**LADACAN's comments on the Applicant's REP10-045 submission****Table 2.1, ID 1 (Climate Change and Greenhouse Gases)**

**Table 2.7 ID 2 (Noise and Vibration)**

The noise monitor was located in Dagnall between 7th May and 2nd July 2019.

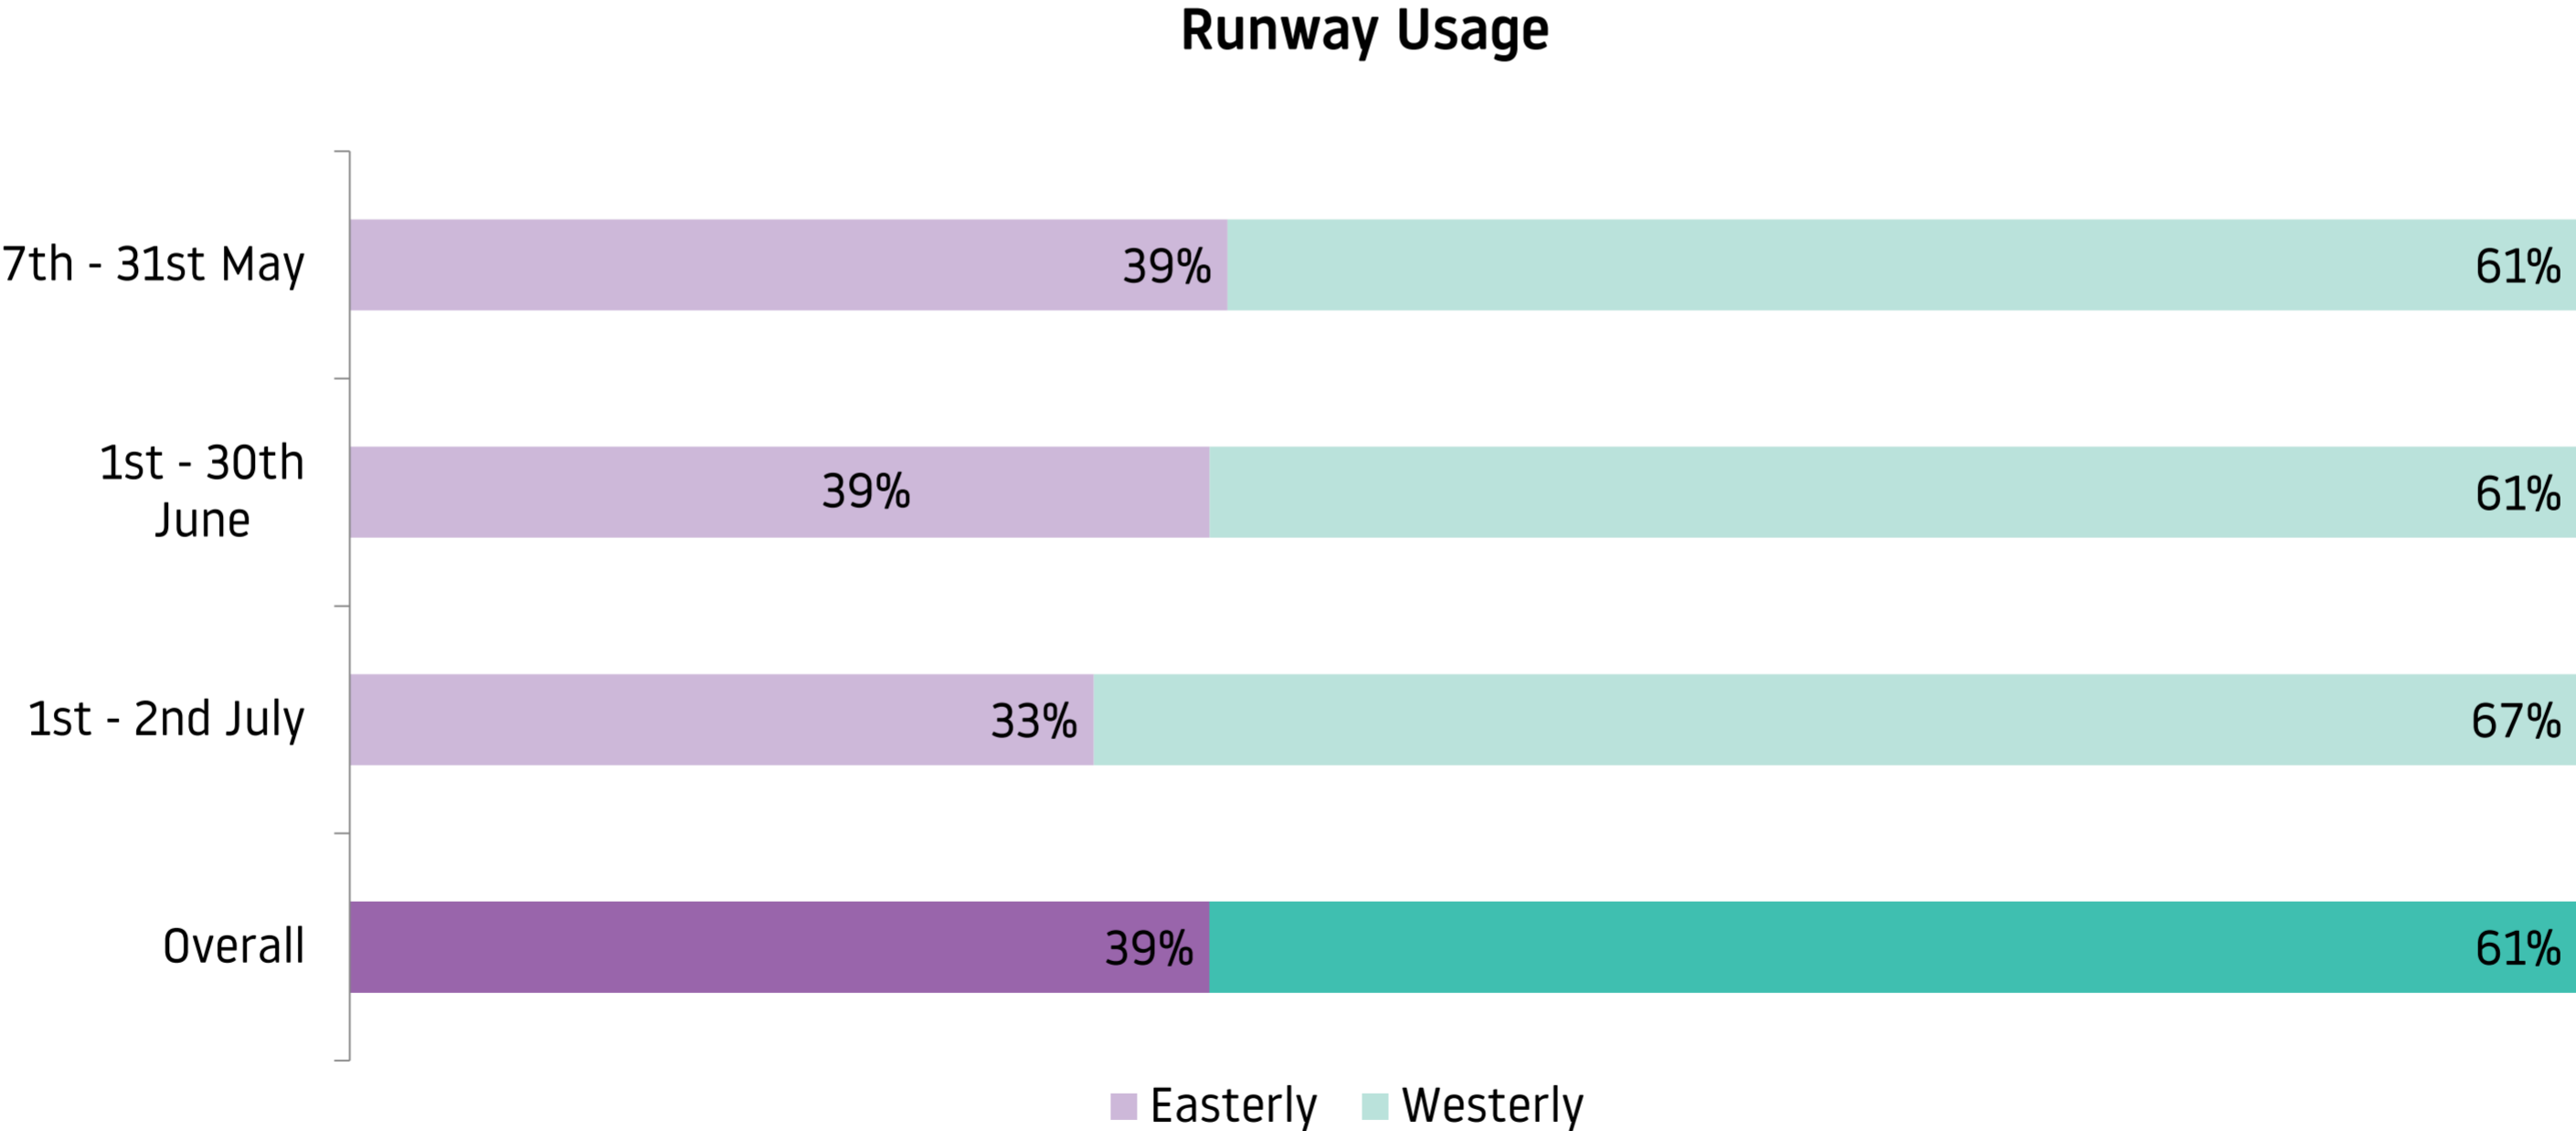
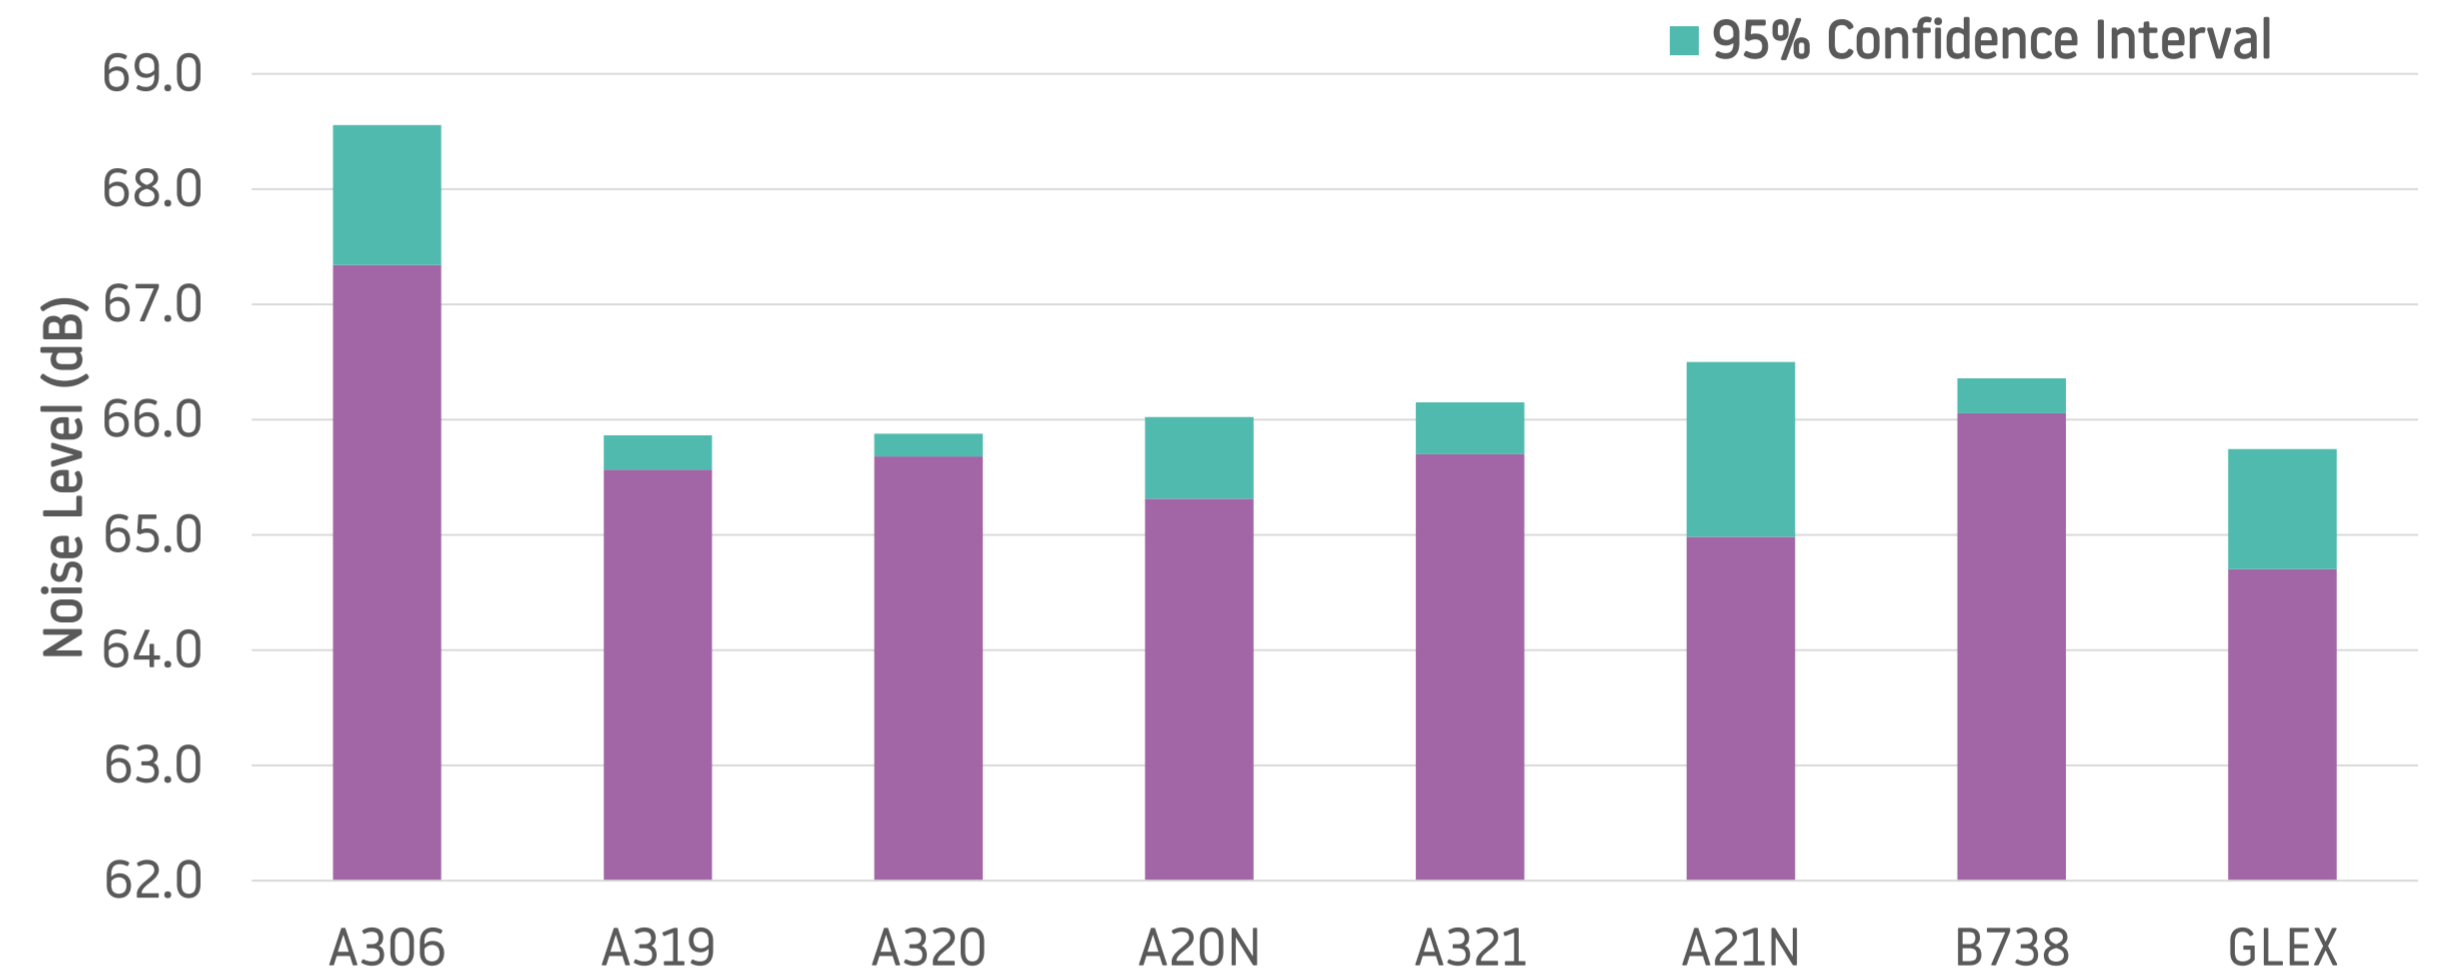
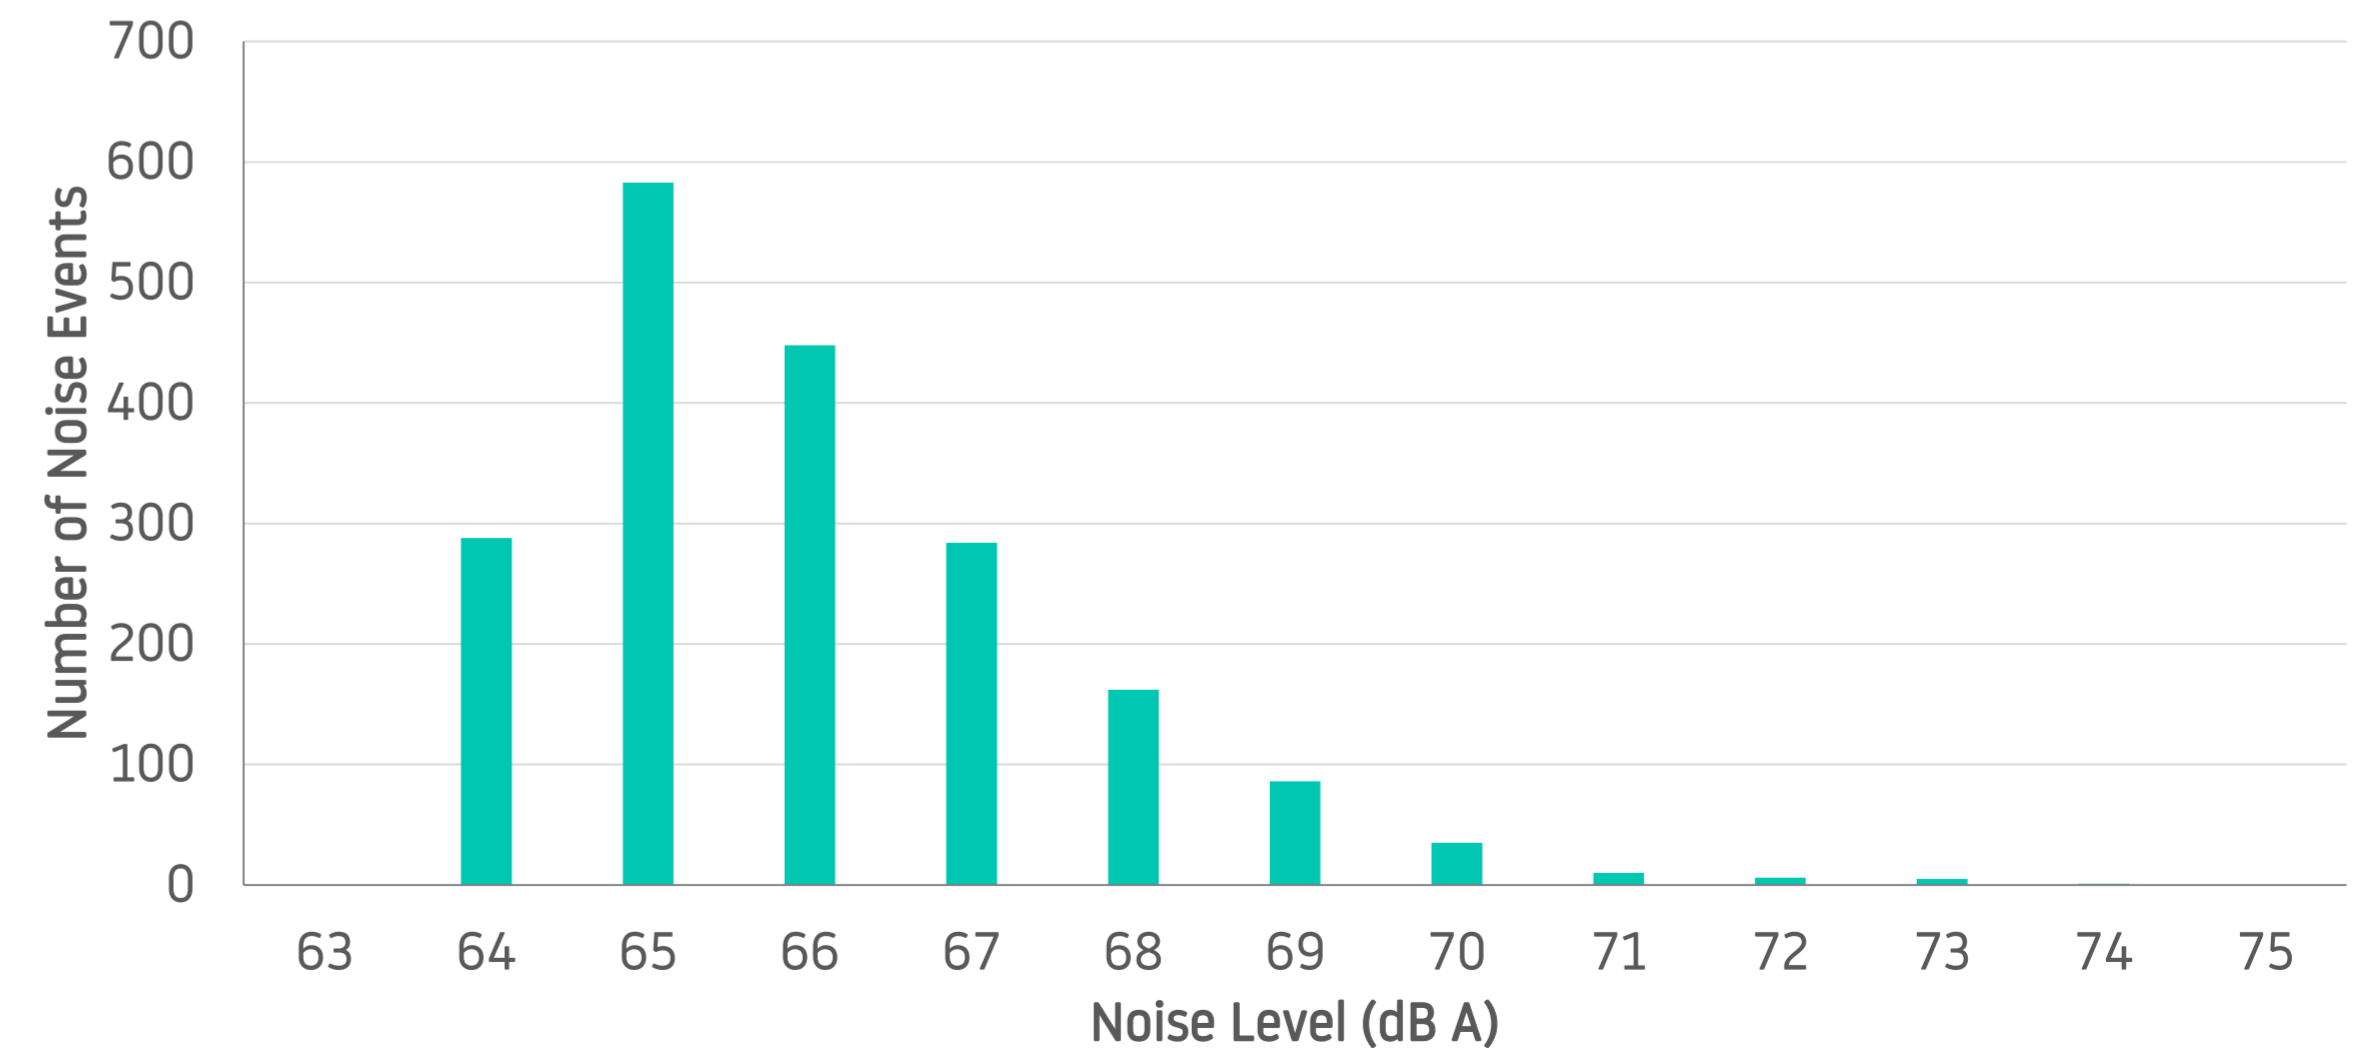
In the case of Dagnall, where all the results are for arrivals, a reduction for each aircraft type is seen, of between **1.4dB** (A306) and **3.3dB** (A320neo) with five of the seven values being by more than 3dB.

The evidence we submitted in REP9-081 Section 2 page 9 suggests that an erroneously high LASmax cutoff value in 2019 is the most likely explanation, since the ‘distribution of noise results’ histogram is quite different between the two monitoring exercises, with that in 2019 clearly truncated at the left:

The effect of this would be to exclude flights with lower-than-64dB LASmax from the correlated data sample, thereby erroneously skewing the average or 50<sup>th</sup> percentile values of LASmax and SEL in 2019.

The 2019 CNR from Dagnall confirms that 60% of the flights had been discarded (by the cutoff):

*“For the monitoring period in Dagnall the Noise Monitoring Terminal collected results for 1,914 aircraft. However, 2,802 aircraft did not register noise events as they were either too high or too quiet, 6 results were excluded for weather reasons as outlined above, which left 1,908 noise results to analyse.”* (page 8)
